Application by Fosse Green Energy Ltd for an order granting development consent for the Fosse Green Energy solar farm

**Deadline 5 –
Comments on Submissions and
Information Received at Deadline 4**

North Kesteven District Council

28th April 2026

Figure 3-2B SHEET 1

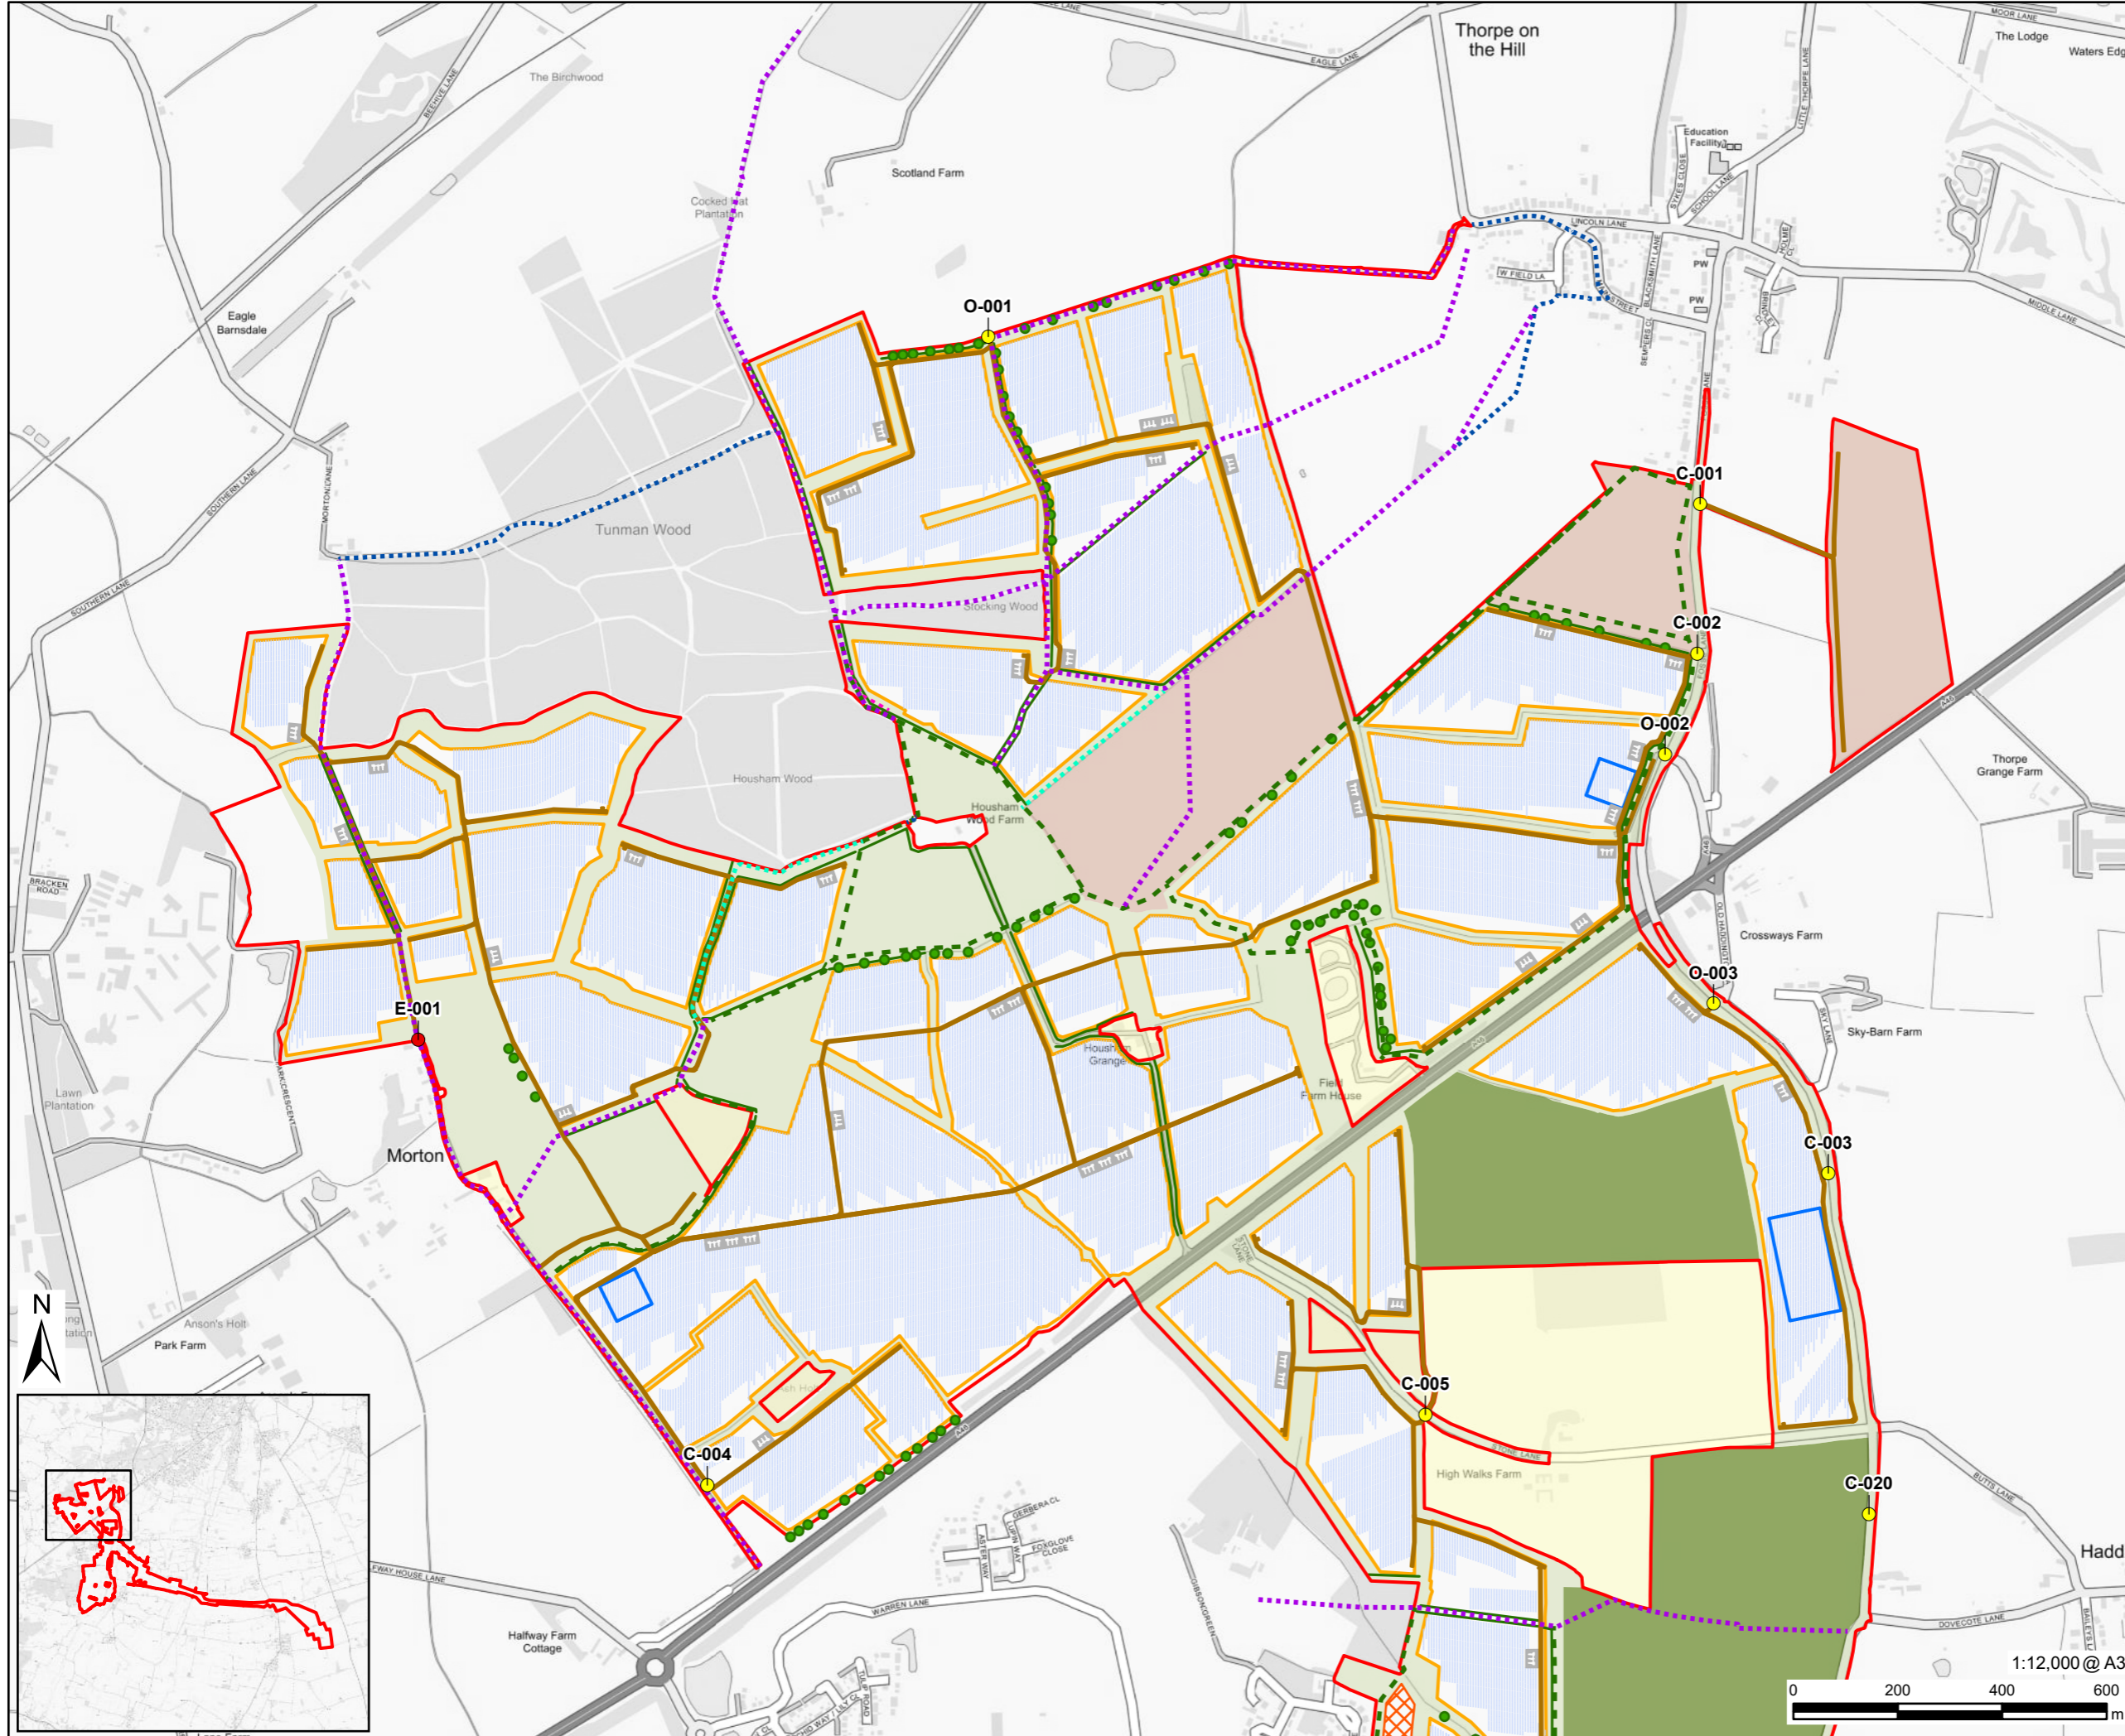
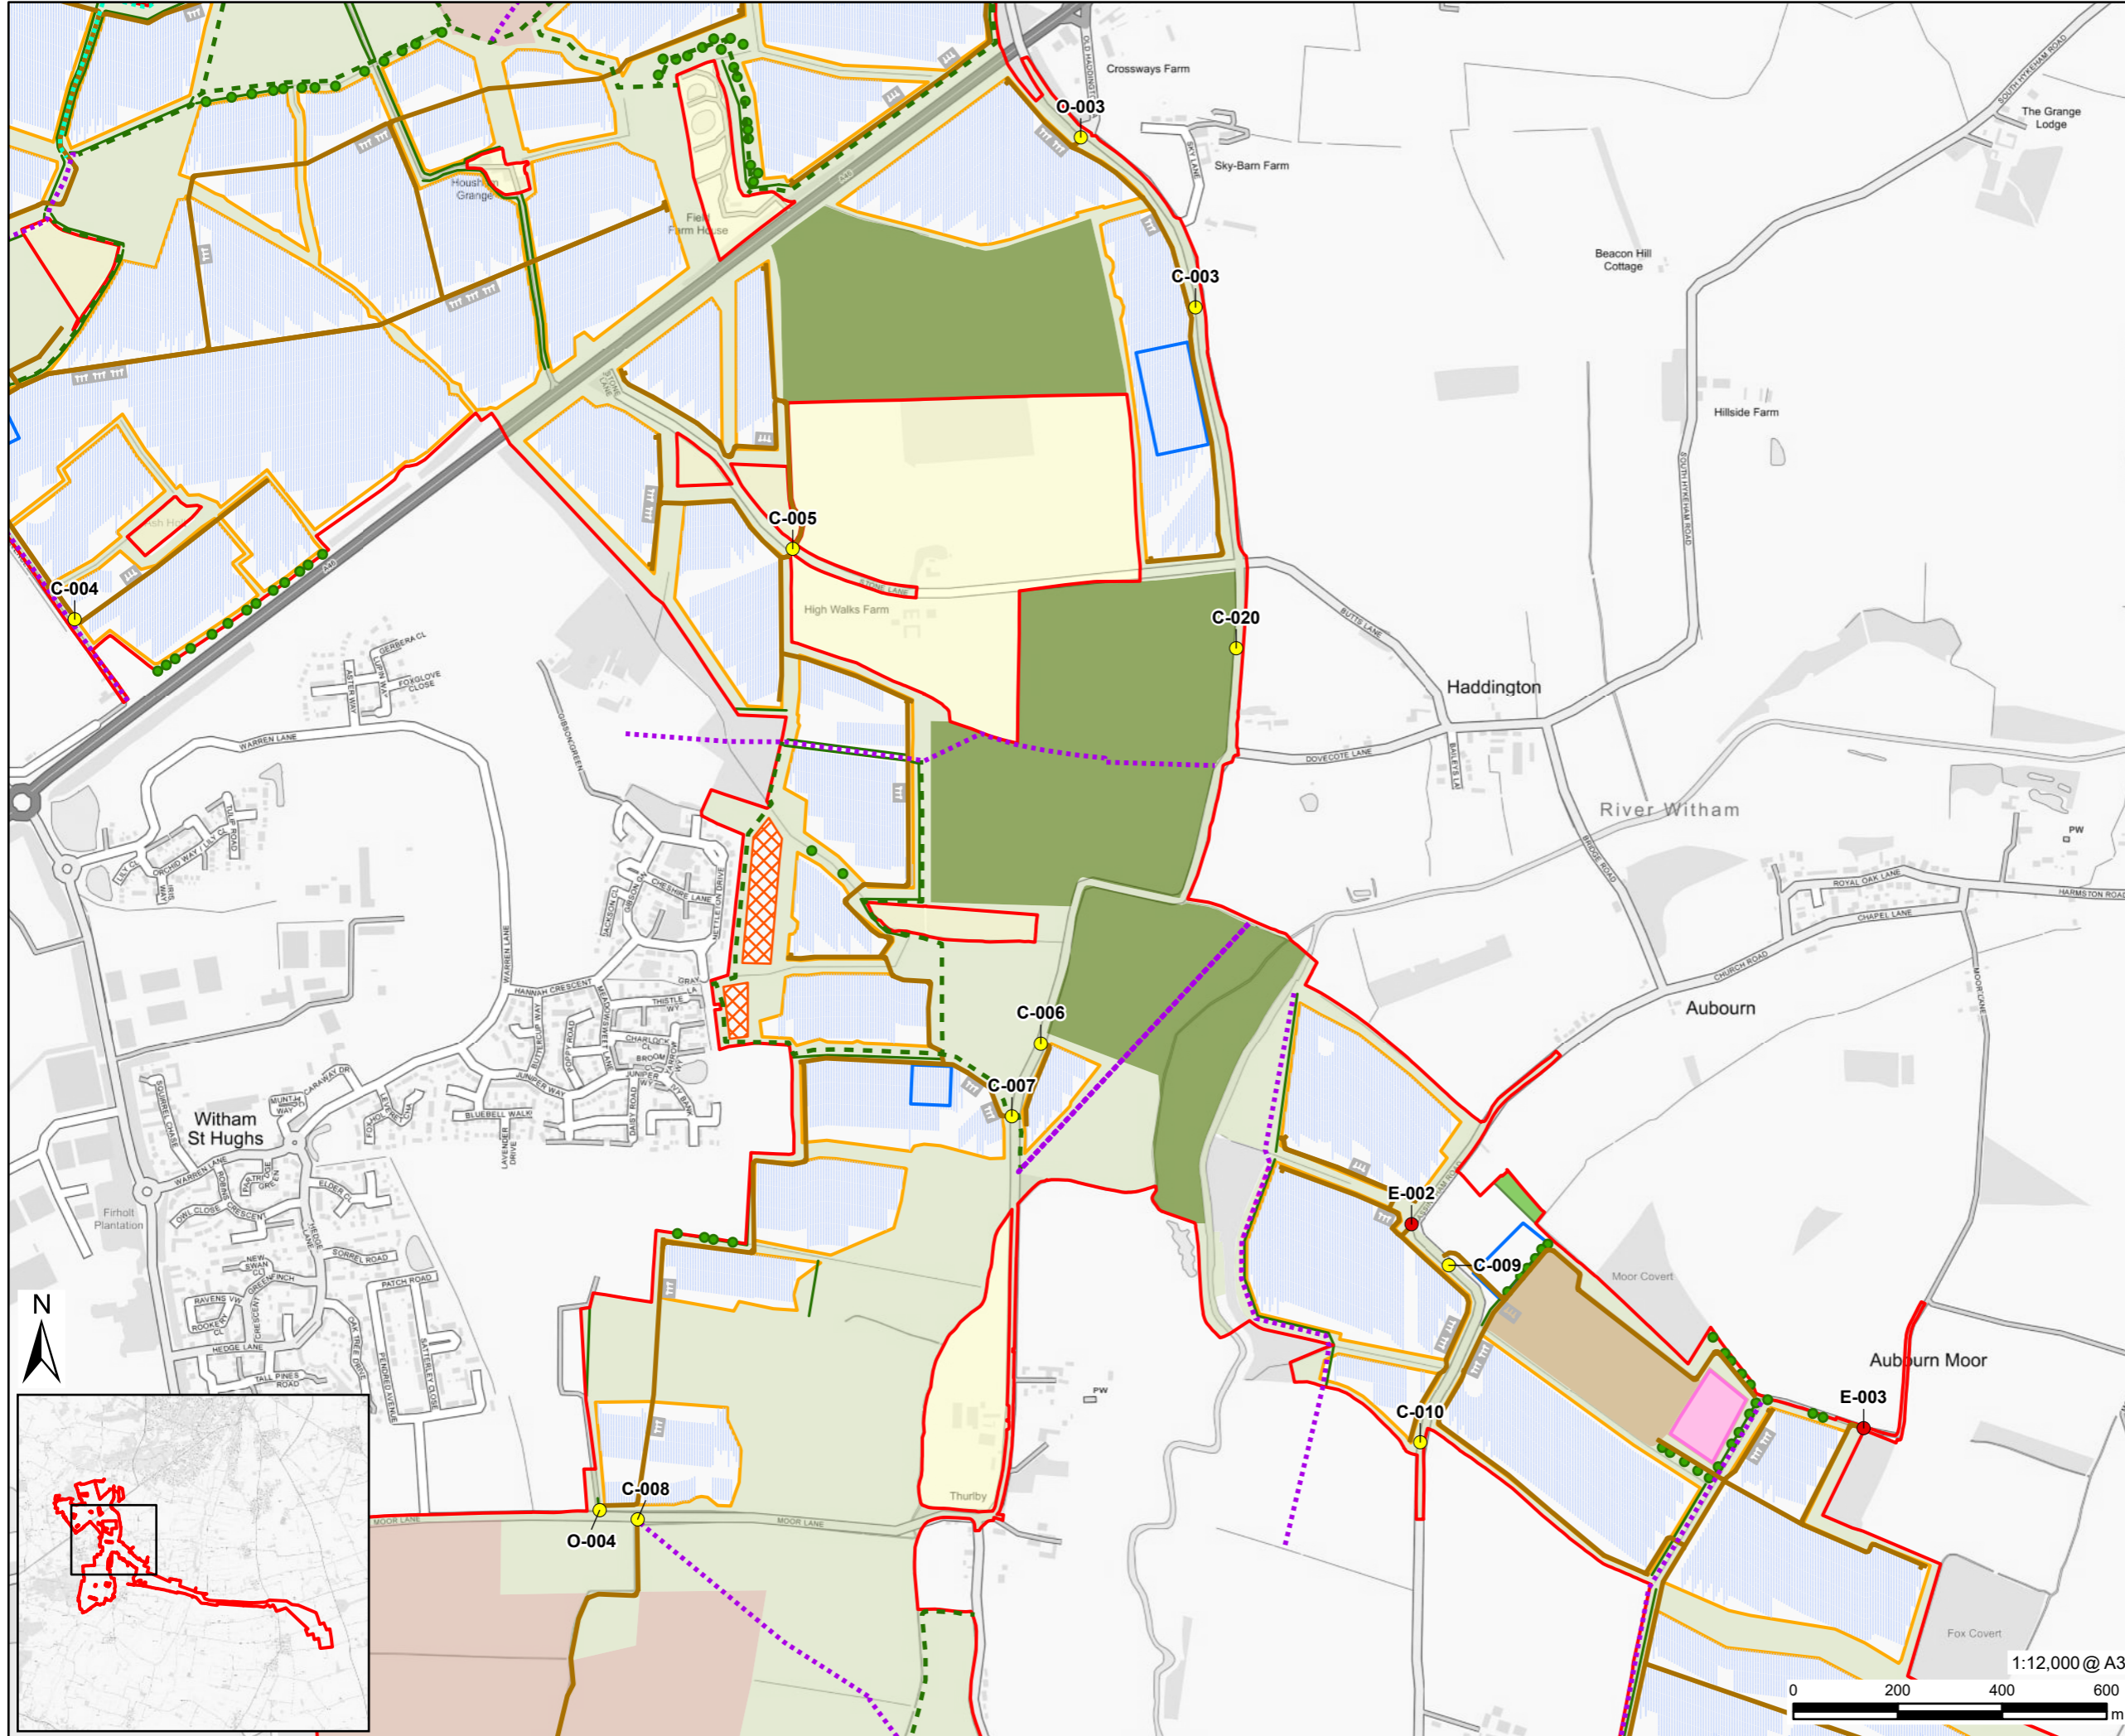
20. The Applicant has submitted the following drawings as indicating its revised approach to the provision of permissive paths:
 - REP4-006 : Figure 3-2A Indicative Fixed South-facing Site Layout Plan

- REP4-007 : Figure 3-2B Indicative Single Axis Tracker Site Layout Plan
21. These drawings are labelled 'indicative', and are not intended to be certified documents. The Council looks forward to having sight of the final permissive path proposals on the Landscape Mitigation Plan contained in the Framework Landscape and Ecological Management Plan, as it is that document which is referred to in the definition of Permissive Paths in the draft DCO, article 2 (REP3A-029). Also showing the permissive paths on the Streets, Rights of Way and Access Plans will be helpful in showing how they connect to the statutory public rights of way network.

23. The changes to the permissive path routes in the area around Thorpe on the Hill, Morton and Tunman Wood represent an overall minor improvement on previous

proposals. The loss of some lengths of the existing Stepping Out permissive routes – for instance the valuable walk along the southern side of Housham Wood – is offset by the retention of the length of permissive path alongside the eastern side of the wood north of Housham Wood Farm. The new route also avoids “funnelling” walkers between panel arrays heading south from Housham Wood; but on the other hand the loss of a length of permissive path to the east of Housham Wood Farm means directing walkers along the public rights of way immediately to the north, where they would have to pass between areas of panel arrays.

24. These changes do not significantly reduce the adverse effects on the experience for users of the two Stepping Out Walks: Morton and Tunman Wood, and Thorpe on the Hill. It is clear that users would experience the loss of open, undeveloped and wide rural views – a major factor in the design and promotion of these walks. The Applicant has never properly acknowledged the value of these walks in terms of their potential to deliver on recreation, mental and physical health, and tourism objectives. Those effects need to be fully mitigated and compensated for.

25. In terms of the total length of permissive path offered, the Applicant has measured this to be 10.2km. Whilst there are limitations with the scale and accuracy of the plans provided, the Council has measured the total length of permissive path as being 9.8km. But in any case, there are significant limitations to the Applicant’s approach which this highlights. Whilst the provision of permissive paths in general is welcome, the failure to recognise the value of and impacts on the Stepping Out Walks in particular is a deficiency of the application. For instance, the permissive path proposed alongside the A46 may be of value to some, especially the occupants of the caravan park nearby. However, in terms of views and noise, that path would never have been selected as part of a Stepping Out Walk.
